Application No: FG/149/20/PD
Site Address: 11 Sea Lane Ferring BN12 5DR
Description of works: Prior notification under Schedule 2, Part 3, Class O of the Town & Country (General Permitted Development (England) Order (as amended) for the change of use of the existing first floor of the building from office (Class B1(a)) to 4 No. residential dwellings (Use Class C3) .

Thank you for your internet representation made on 19th November 2020 which has been recorded as an objection with the comments as follows:

Project		11 SEA LANE, FERRING	
Client		Kingsley	
Drawing no.		FG/SL/01	
Scale		AS SHOWN	
Date		Sept 2020	
Drawn By		WG

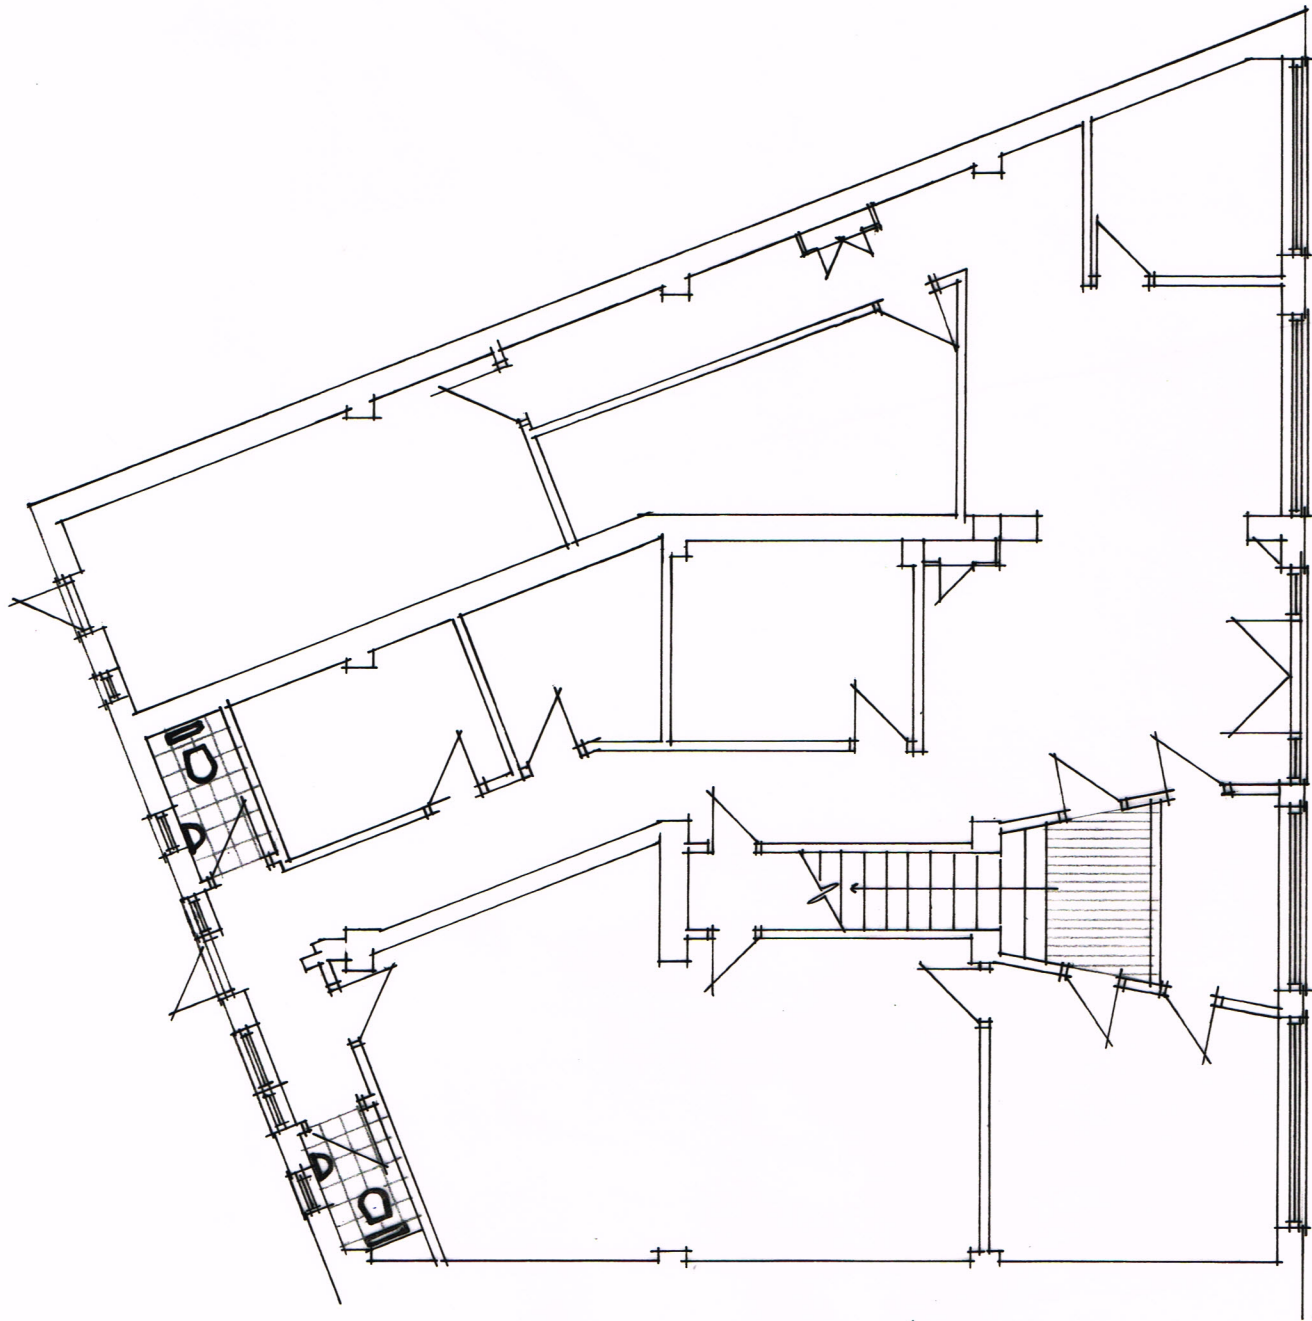
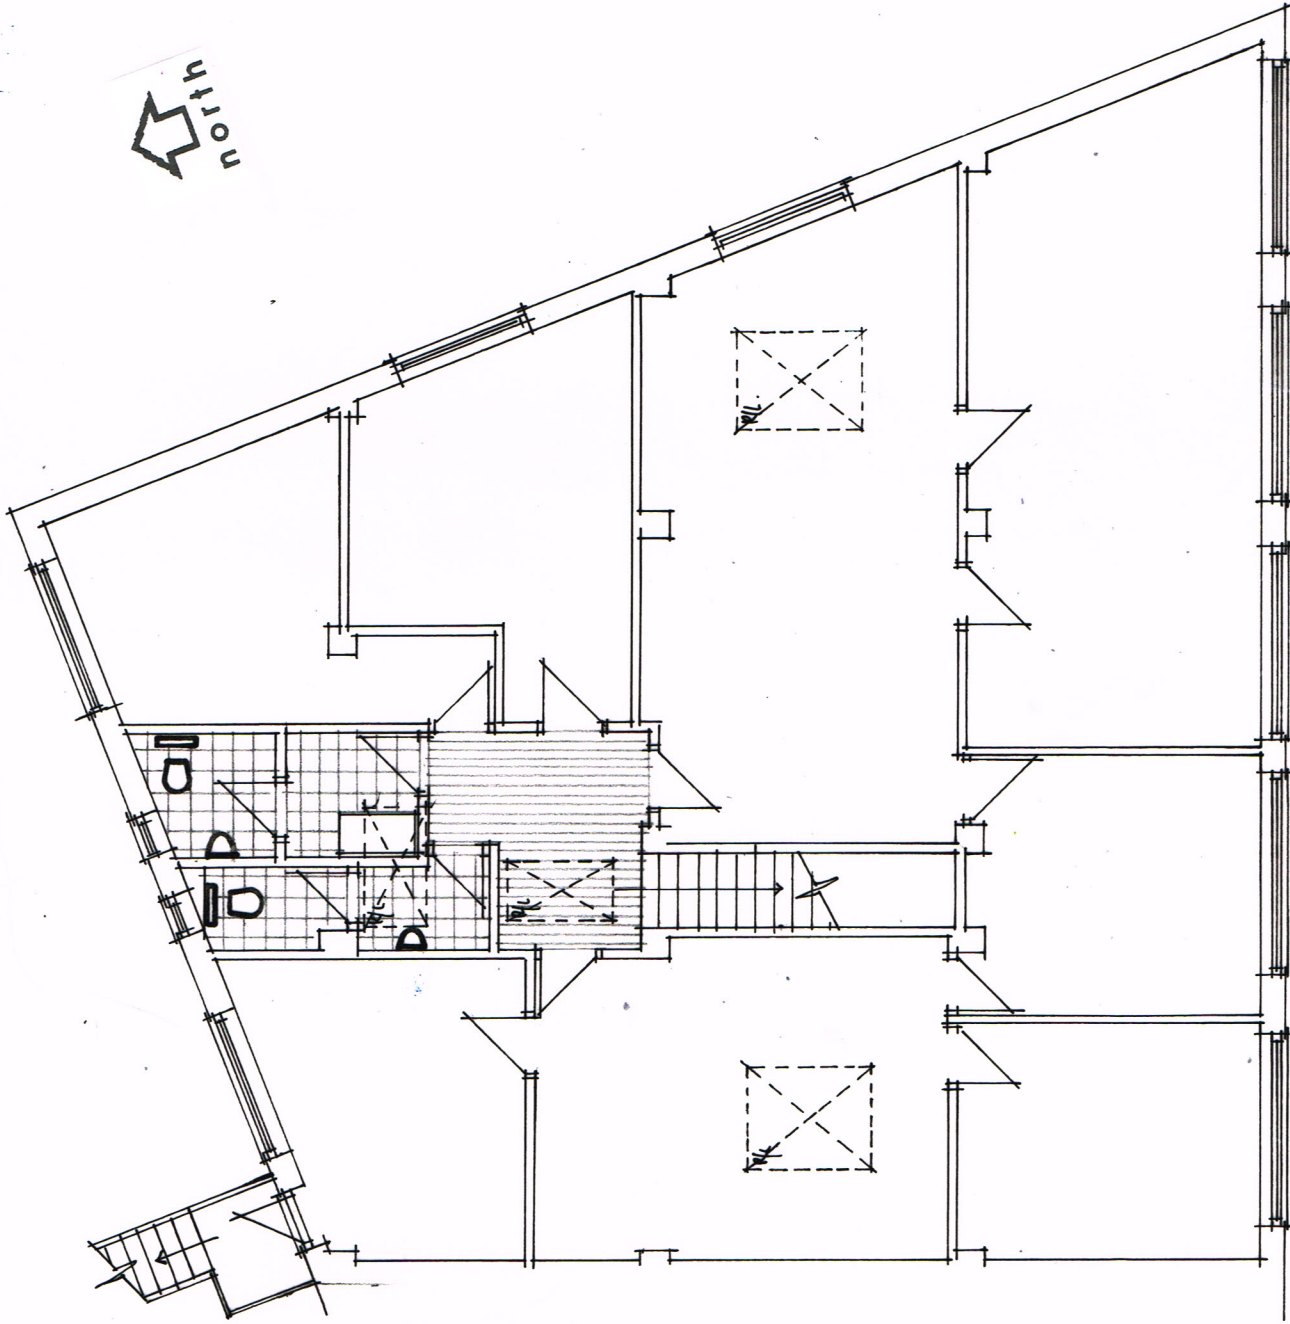
The application is confusing as the proposed and current floor plans appear to be reversed. My objection is to the apparent lack of provision for adequate parking in a busy and generally crowded village location.
